**RE: EXHIBITION OF DEVELOPMENT APPLICATION FOR THE UNIVERSITY OF SYDNEY CAMPUS
IMPROVEMENT PROGRAM 2014-2020 STATE SIGNIFICANT DEVELOPMENT – SSD 13_6123**

That any future approval for the University of Sydney Campus Improvement Program 2014-2020 staged development application SSD 13_6123 be deferred for receipt of amended development application documents that accord with:

Drawing no:	<b>SSD-C-11</b>	Revision:
Date:	06-12-2013	<b>A</b>
Drawn by:	CIS	
Checked by:	JC

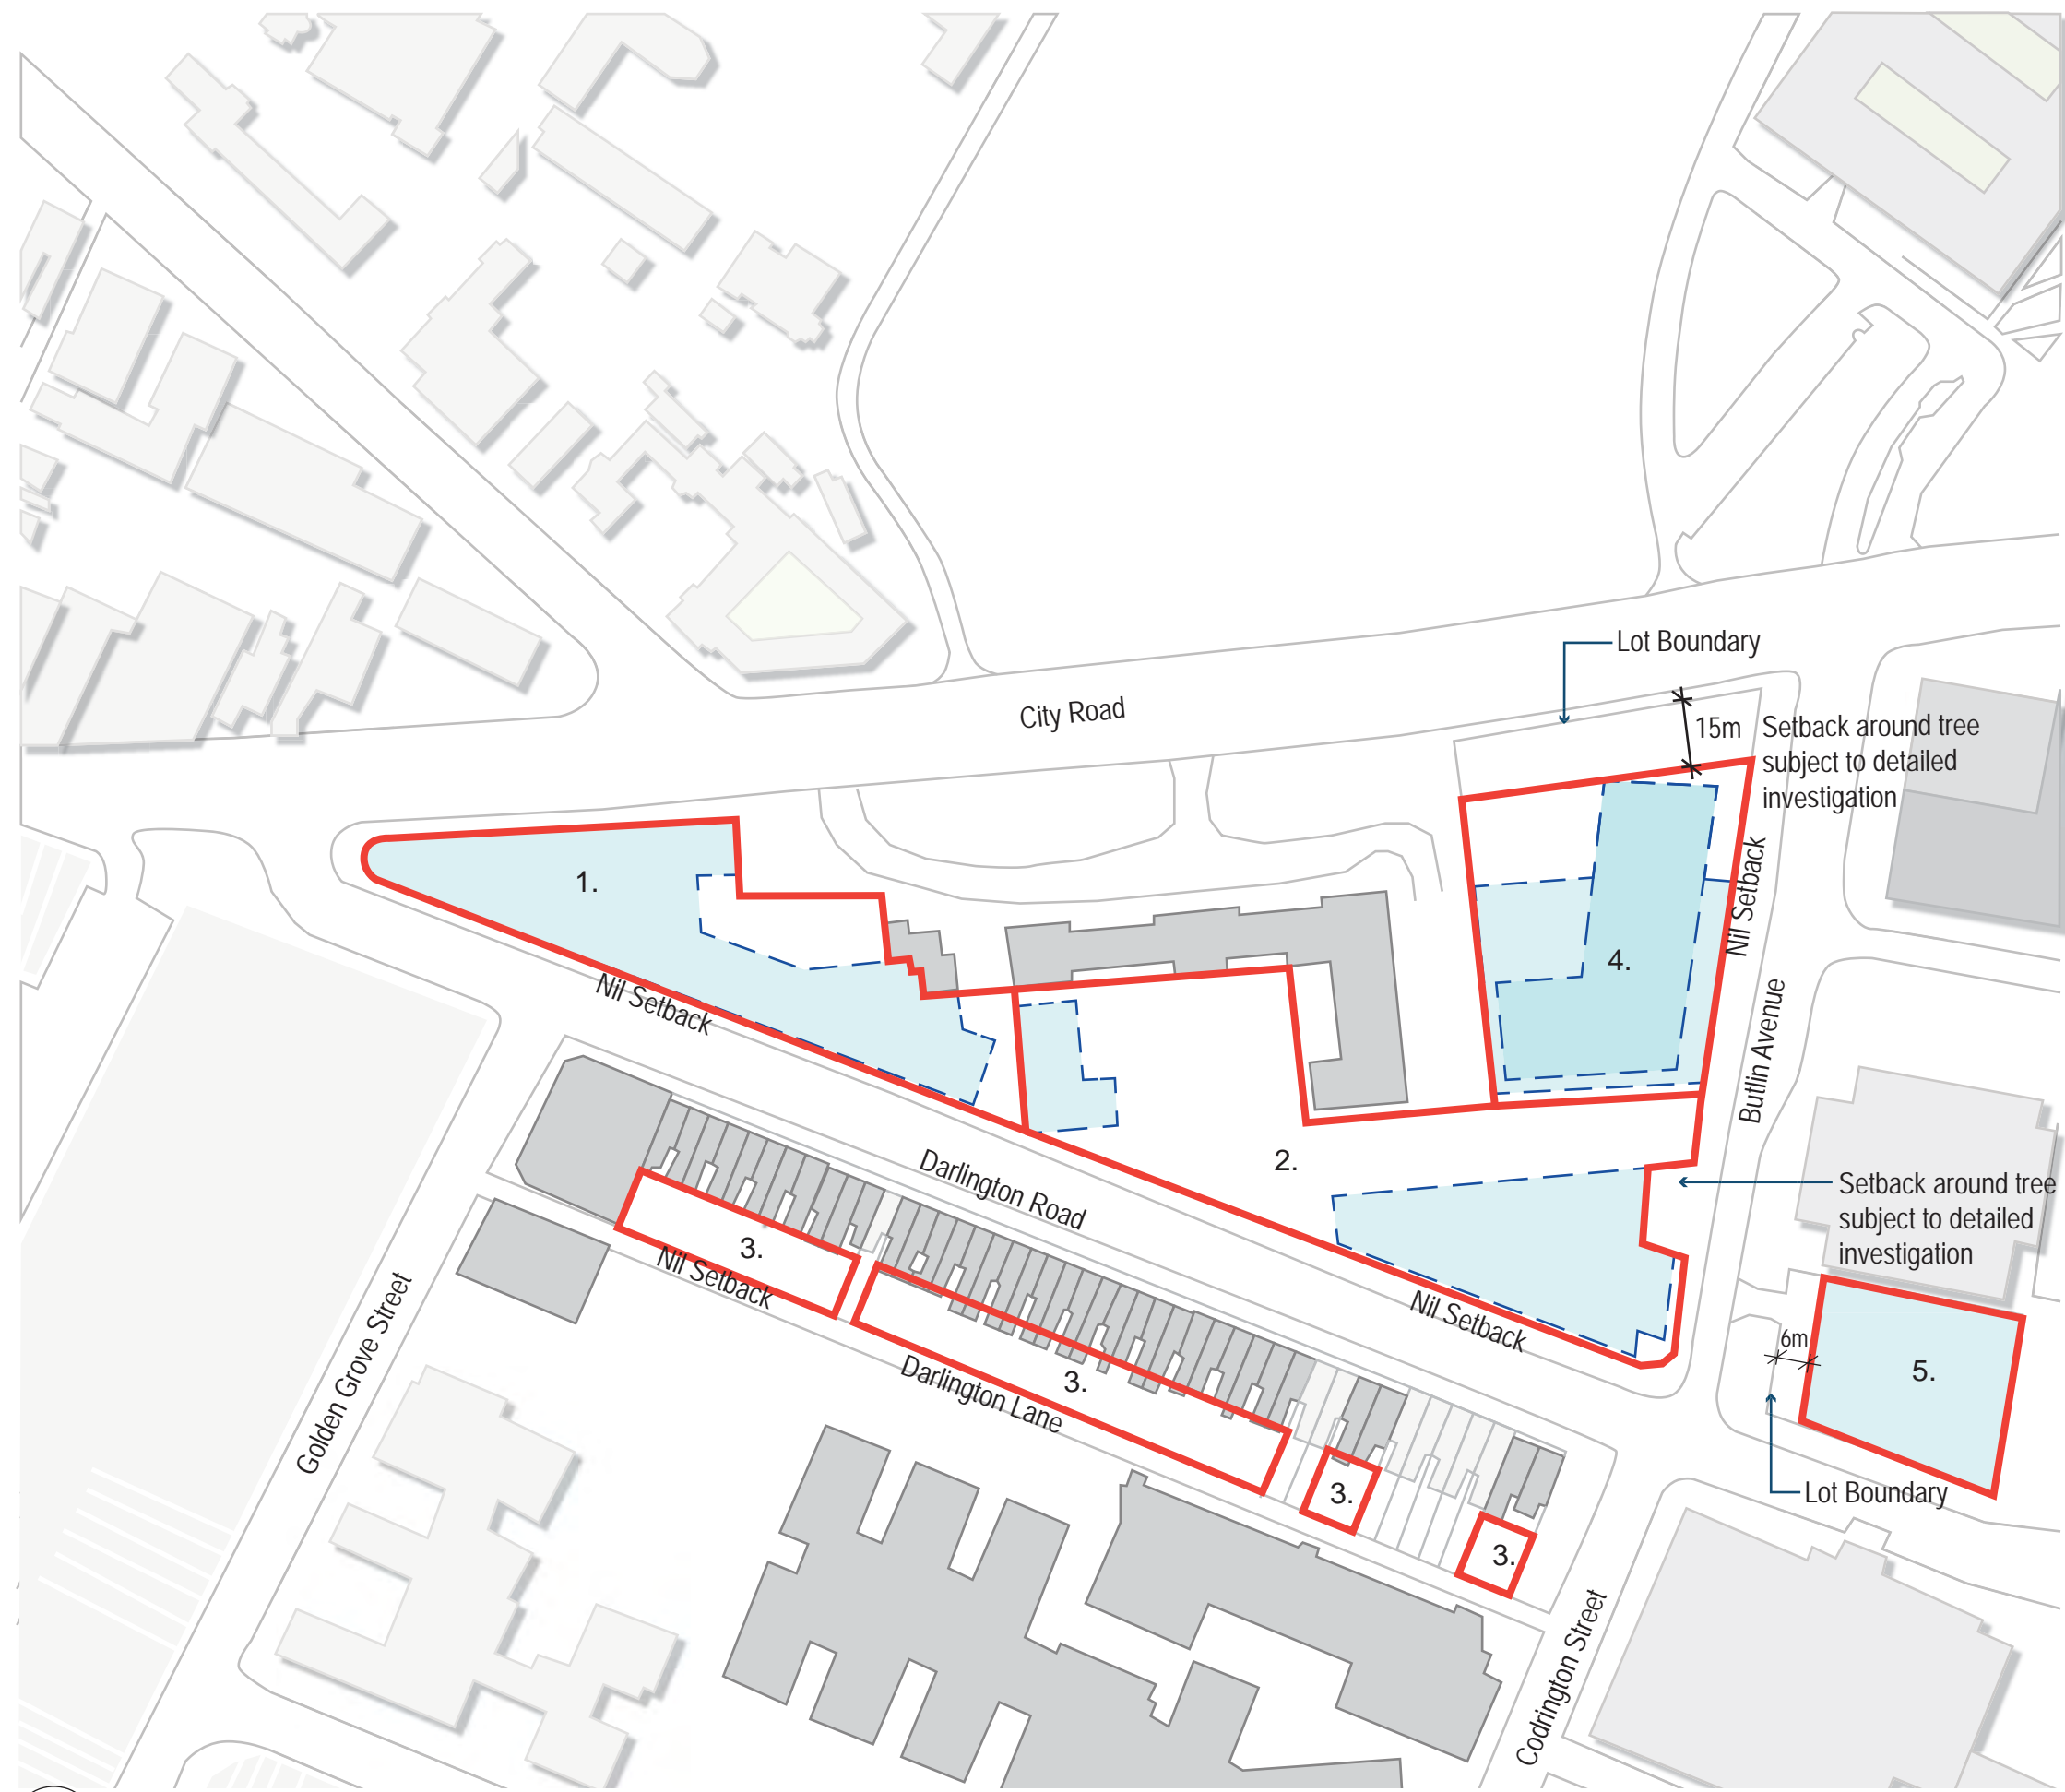
- A heritage curtilage to be established for the Institute Building and Superintendent's Residence to protect views to the buildings and assist in maintaining its heritage significance.

- The volume and scale of future development needs to be carefully considered in relation to the heritage curtilage.
- The west wing of the Institute Building to be retained.

- Sufficient space between new development and the Institute Building must be maintained to preserve the visual integrity of the latter and its relationship to the Superintendent's Residence and boundary fences.

- The *Merewether – Proposed Envelope Plan* (dwg no. SSD-C-11) to be amended to accord with an appropriate heritage curtilage for the Institute Building and Superintendent's Residence.

- The 19th century palisade fence and brick boundary wall around the Merewether-Institute Building site is to be retained and conserved as part of the proposed development.

CAMPUS IMPROVEMENT PROGRAM
2014-2020
**BUILDINGS FOR DEMOLITION
PROPOSED**

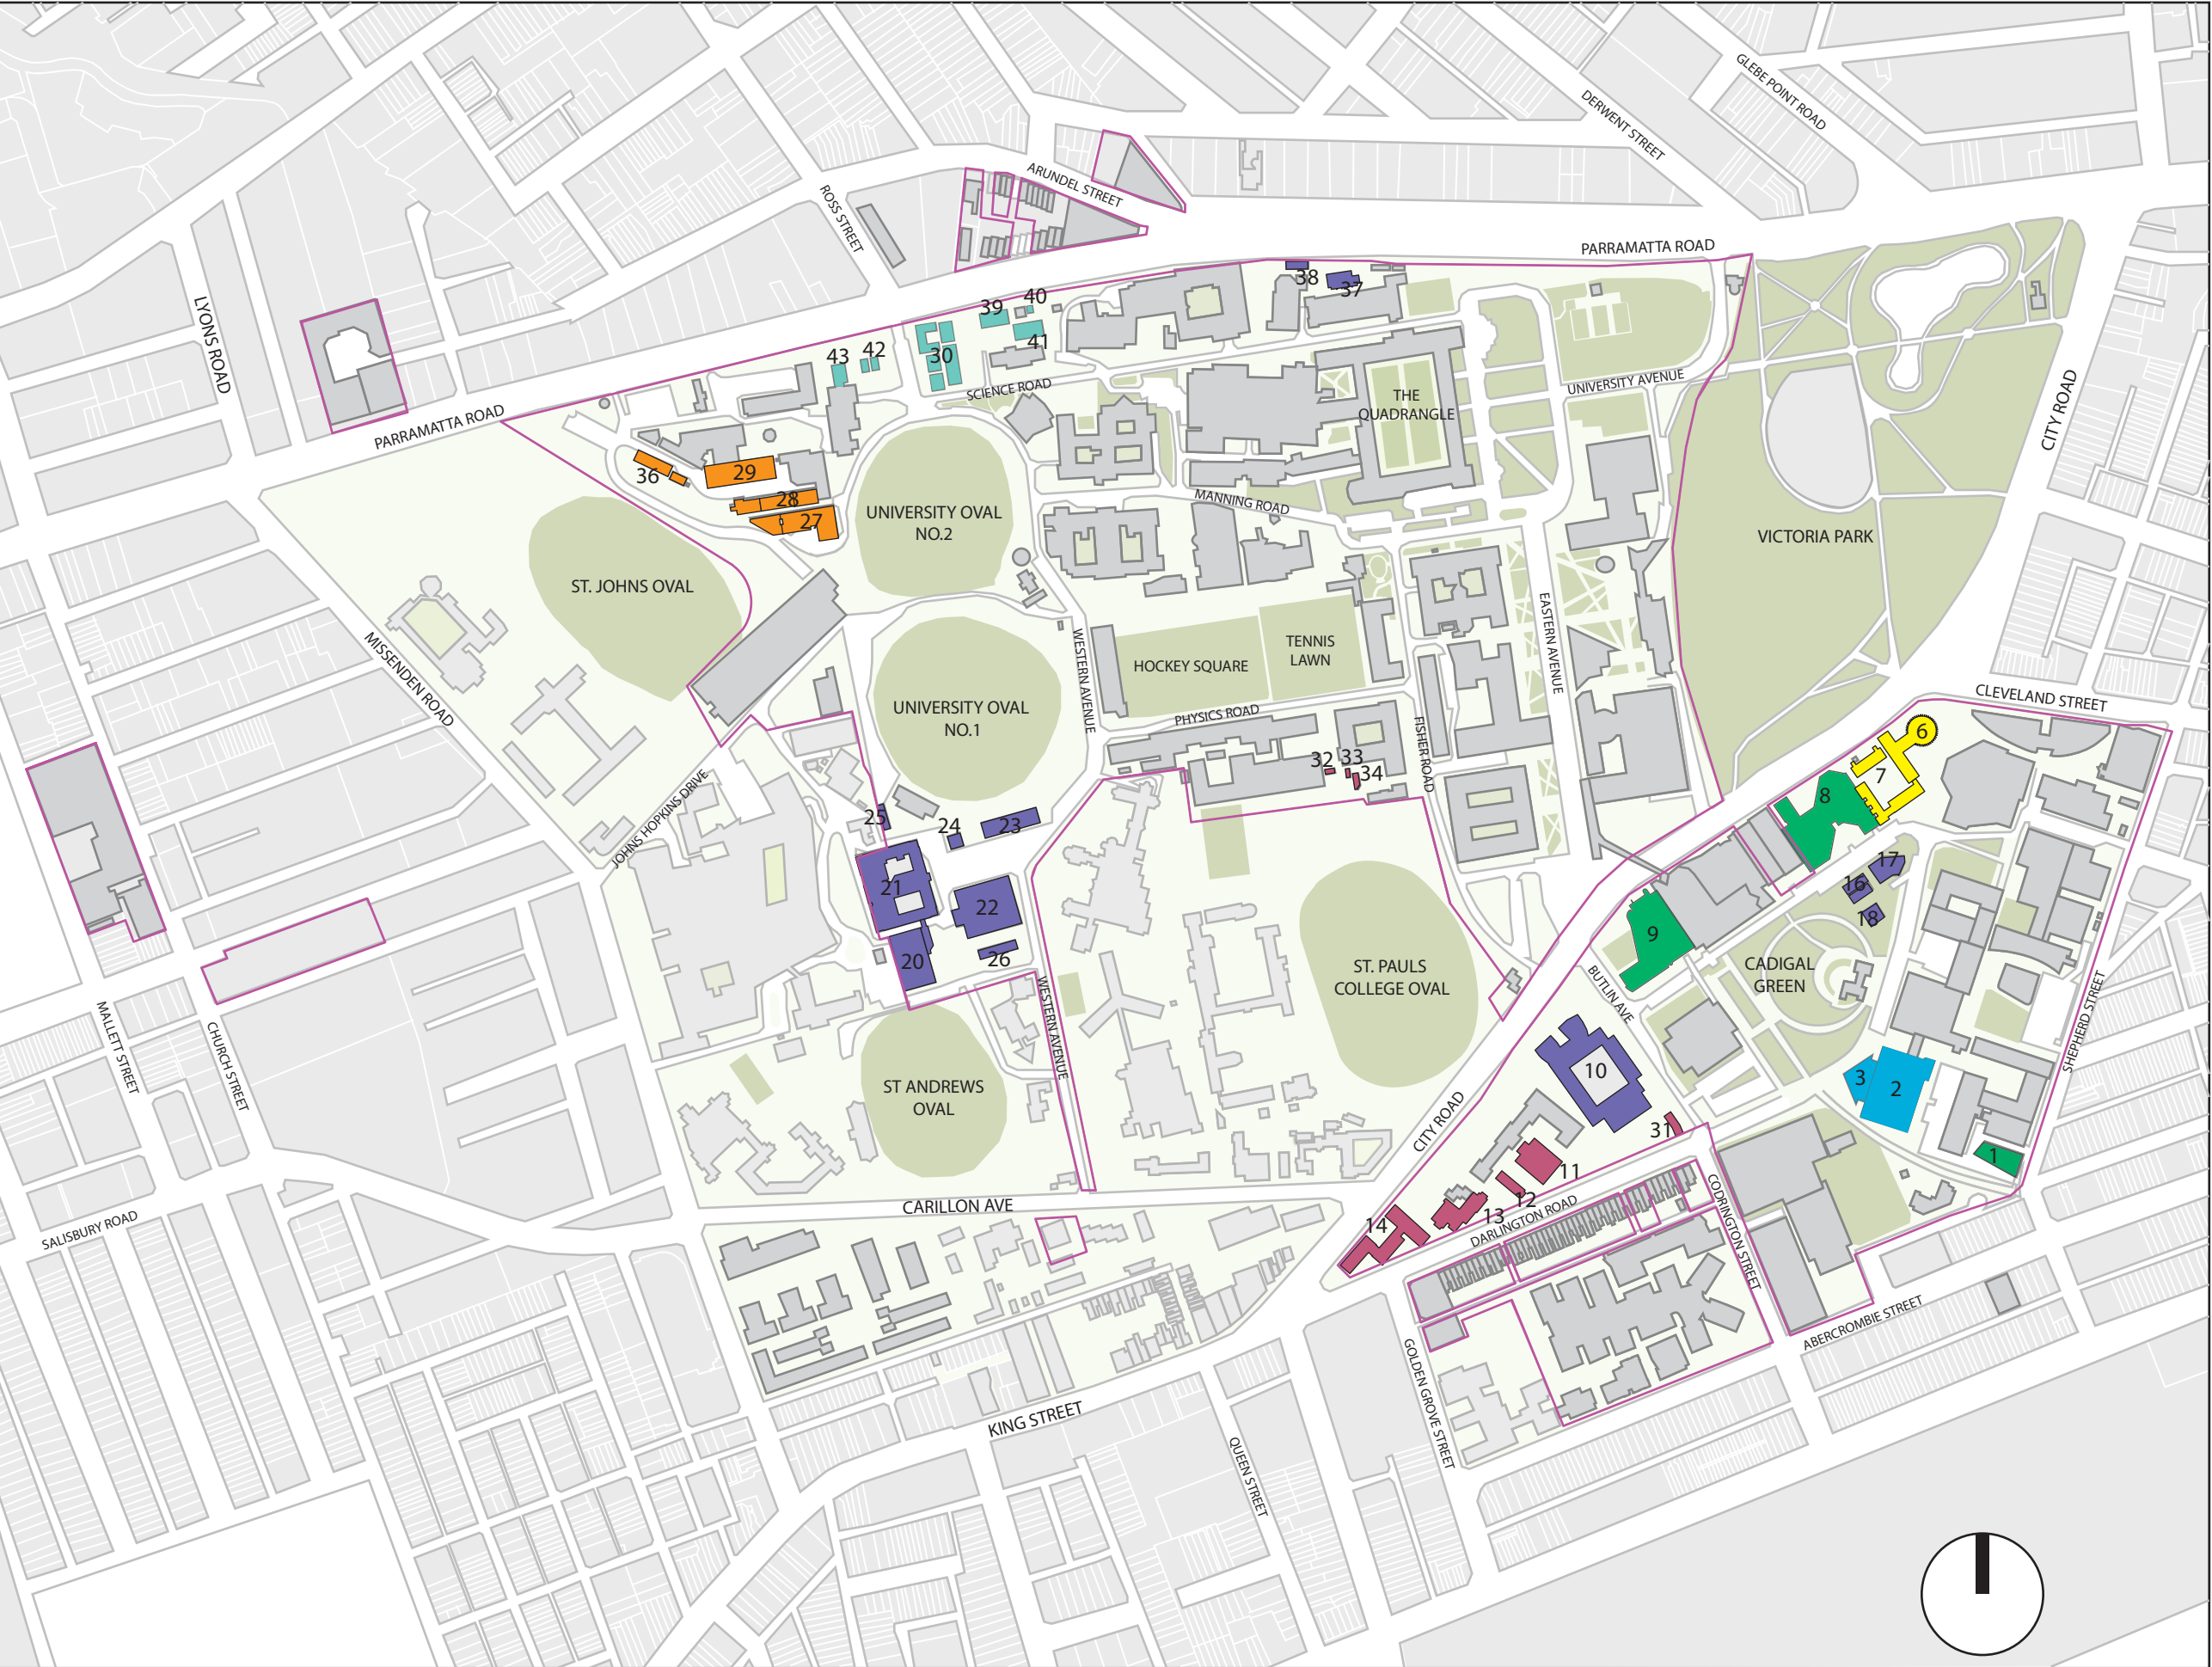
- The University of Sydney confirmed that the Peter Nicoll Russell Building (1966, 1970 Anchor, Mortlock, Murray and Wooley), which is identified as High significance, is to be retained. However, the *CIP 2014-2020—Buildings for Demolition Proposed* plan indicates the PNR Building is proposed for demolition and should be amended to indicate the building is to be retained.
